DECISION DELEGATED TO HEAD OF PLANNING

Application No: H03-0876-24 **Applicant:** PN Watts

Proposal: Change of use of land for use as dog exercise paddock to include associated gravel car parking area, fencing and field shelter

Location: Agricultural Land Opposite Vine House Farm A1175 Main Road Deeping St Nicholas

Site Plan - 1:500

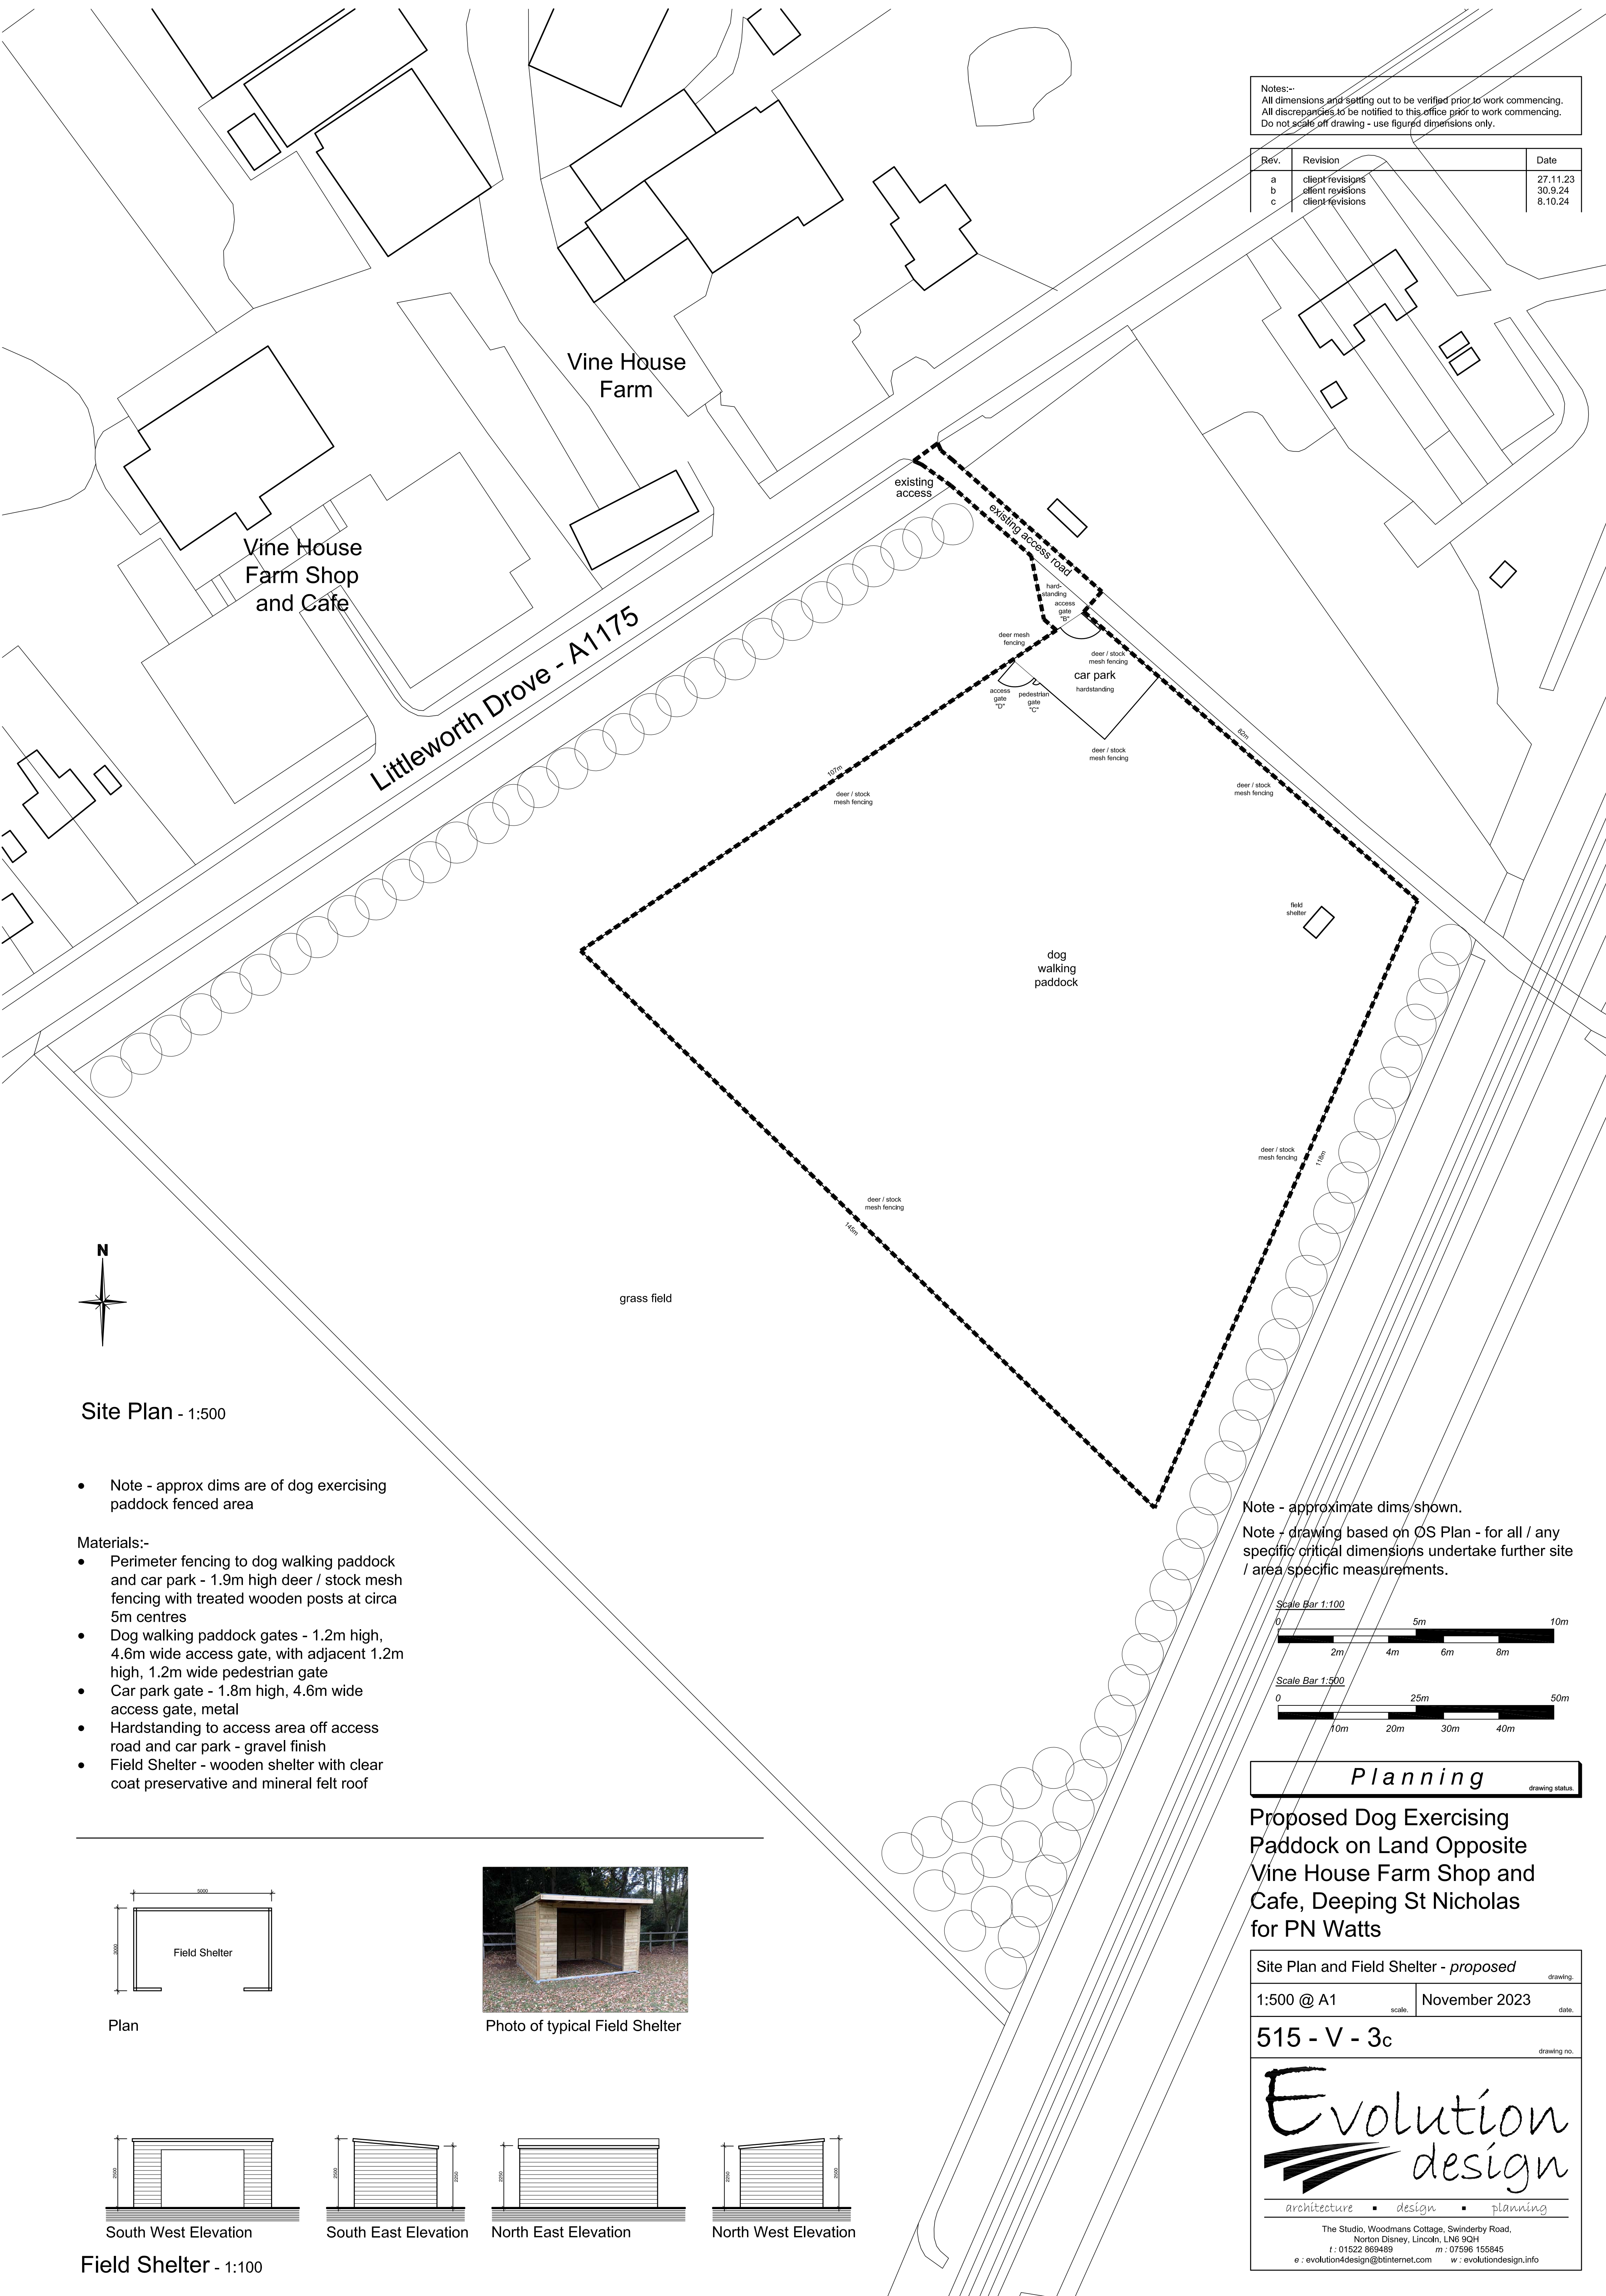
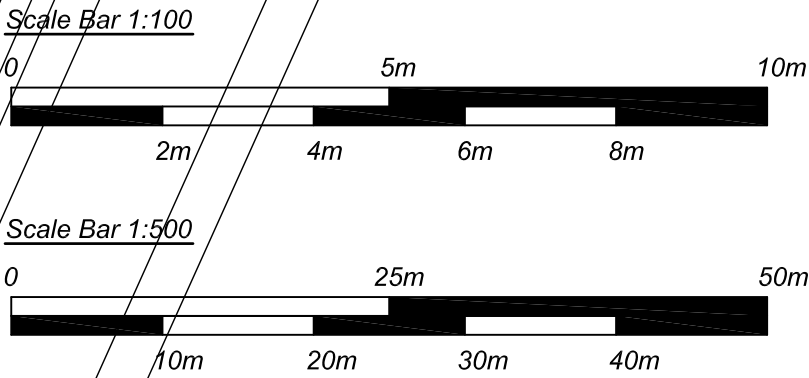
First Response (28 November 2024): Additional information is required. The width of the access and track needs to be demonstrated on the site plan. It needs to measure a minimum of 4.5m wide

at the highway boundary and for the first 10m thereafter it shall measure 3.7m. As there will be two-way traffic these dimensions are necessary. 3 parking spaces do not seem sufficient for the use. If a max of 3 cars is limited per hour, they need to provide more parking particularly if there is an overlap of people arriving/departing. 6 spaces would be more appropriate. This is in addition to a turning facility.

Site Plan - 1:500

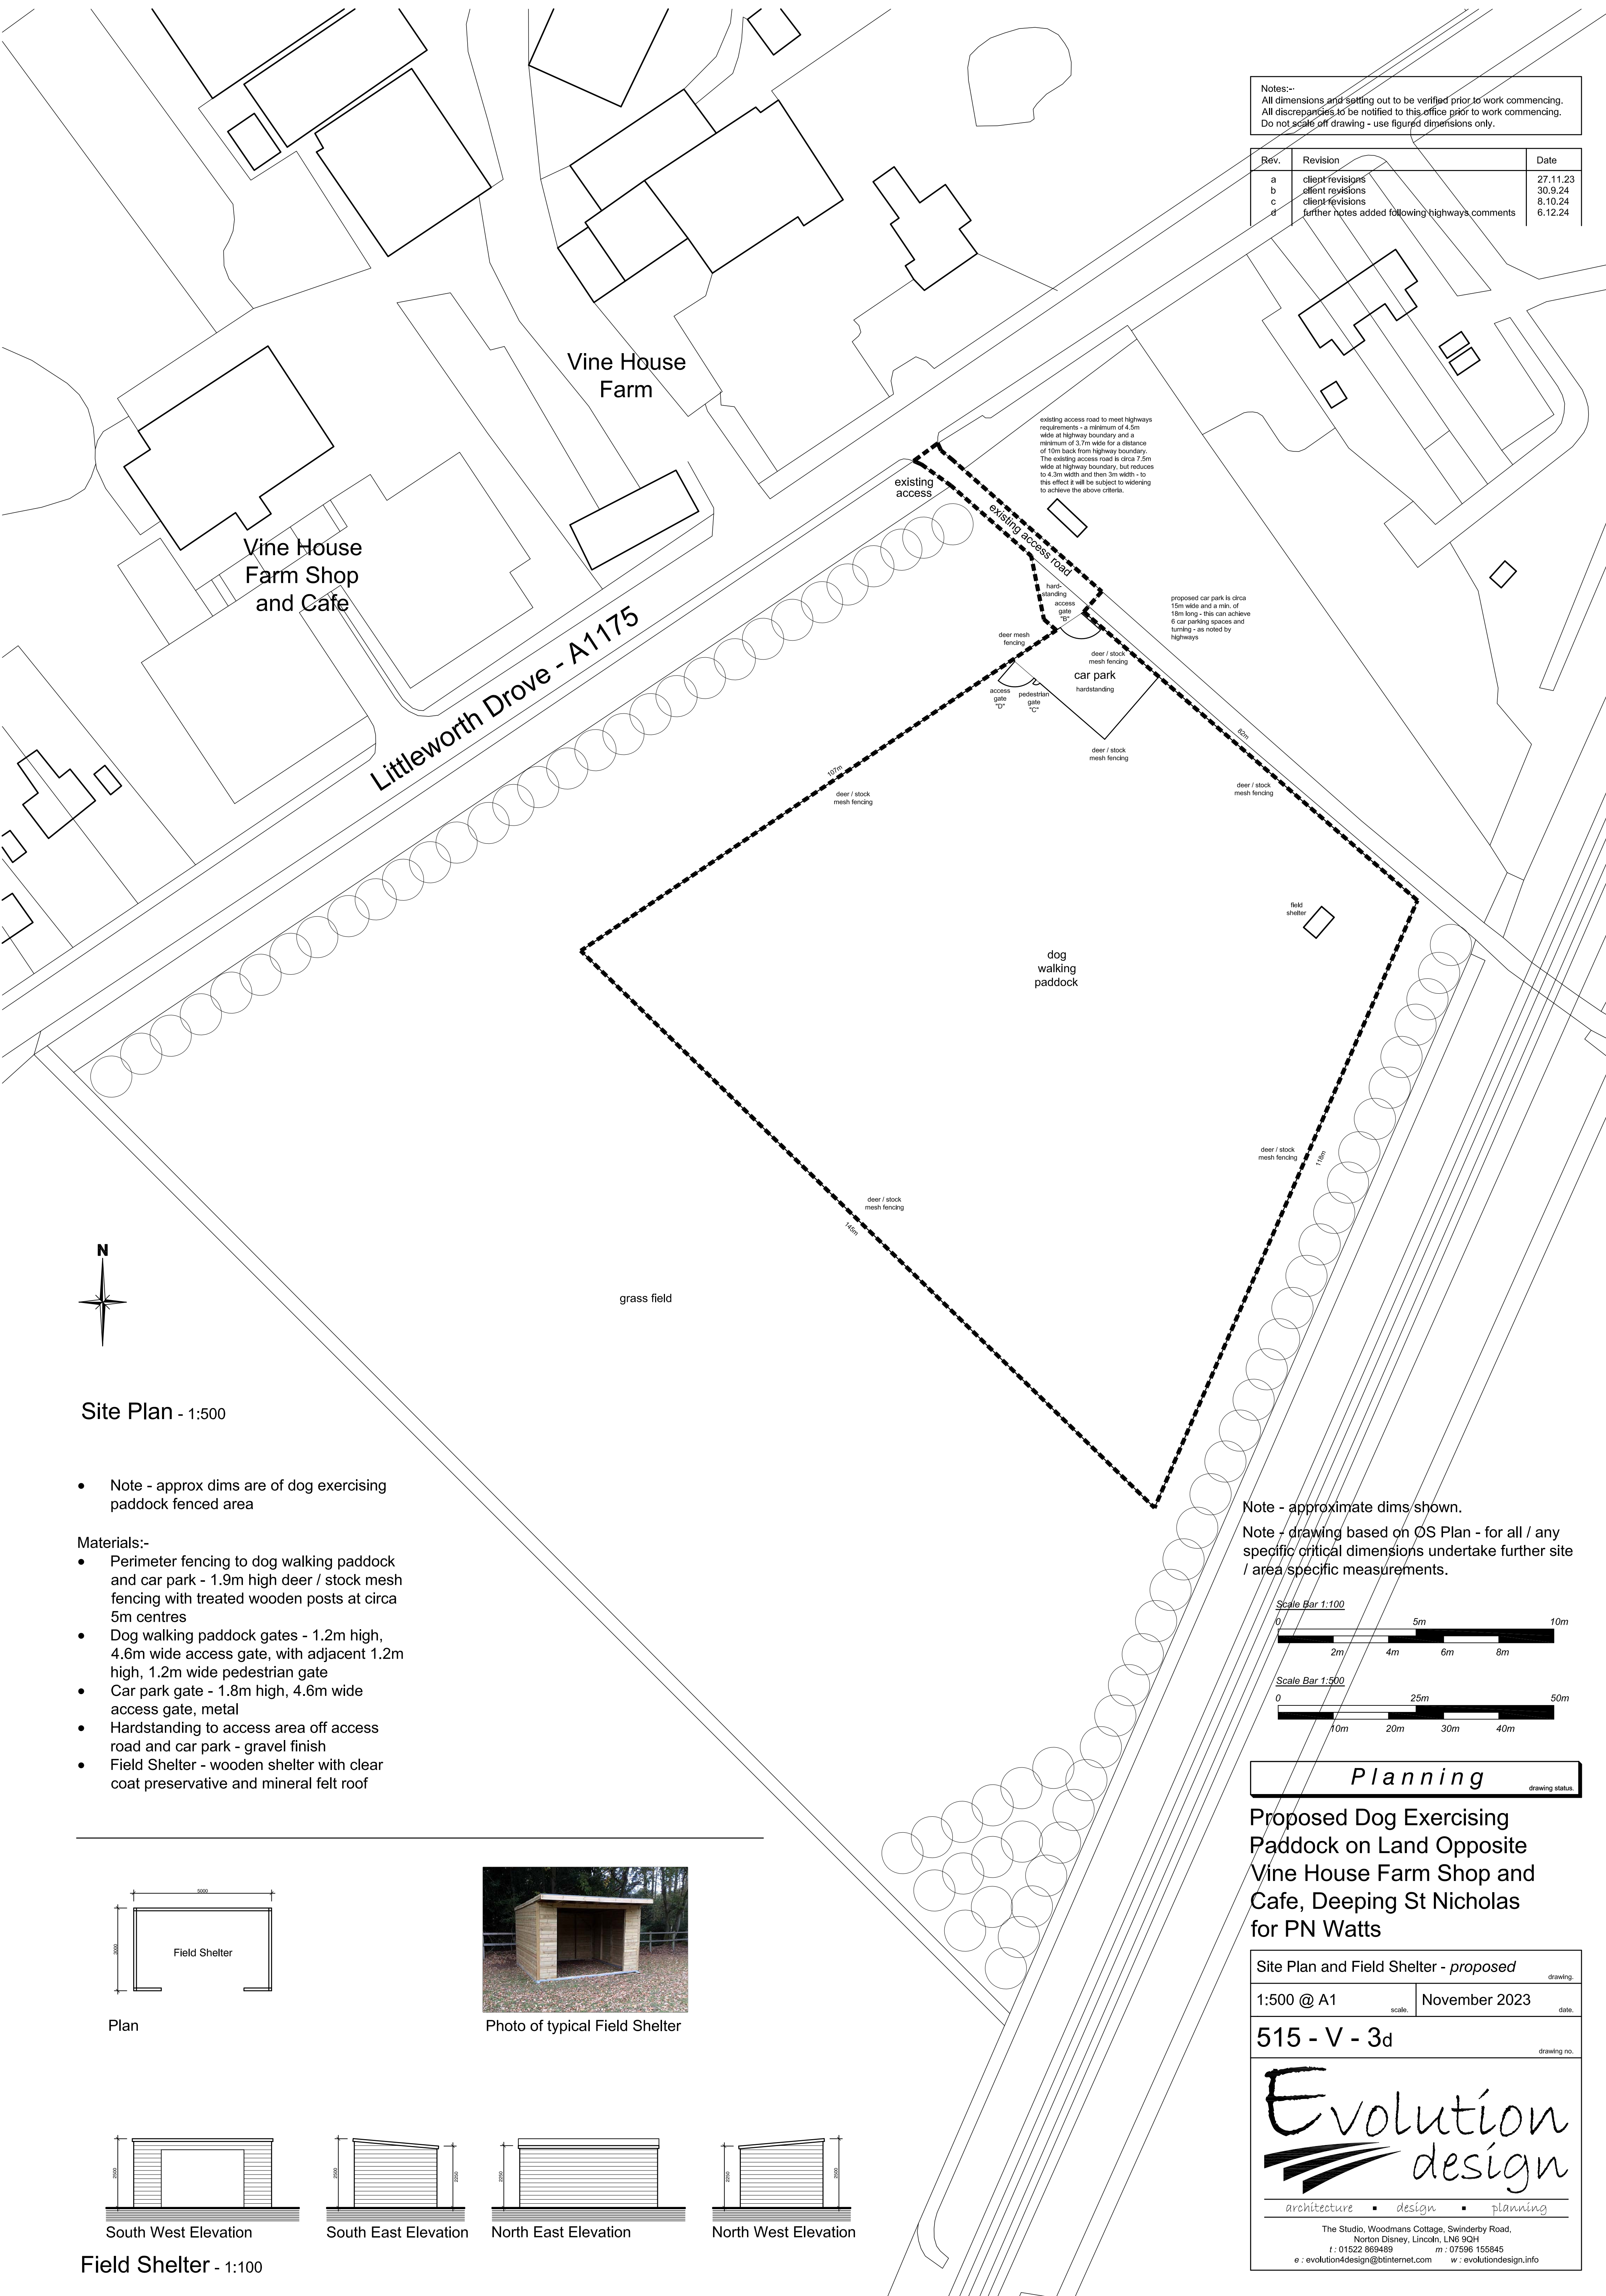
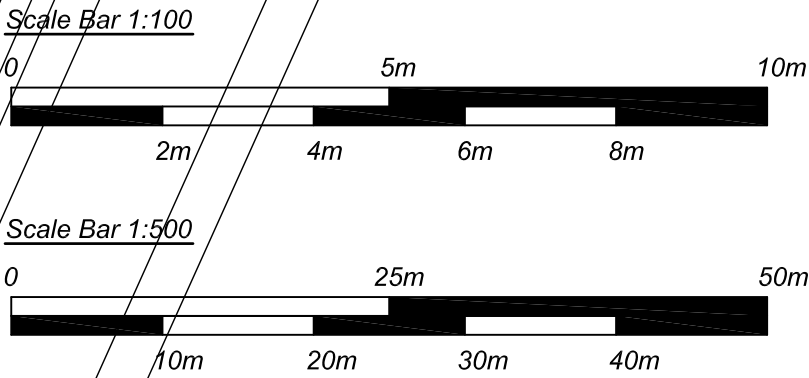
Second Response (17 December 2024): They have misunderstood my comments regarding the access widths. The note is incorrect on the updated drawing. It should read "a minimum of 4.5m for a distance of 10m thereafter it shall measure 3.7m". Or alternatively they just need to demonstrate on plan this criteria. They need to demonstrate the parking ideally as well.
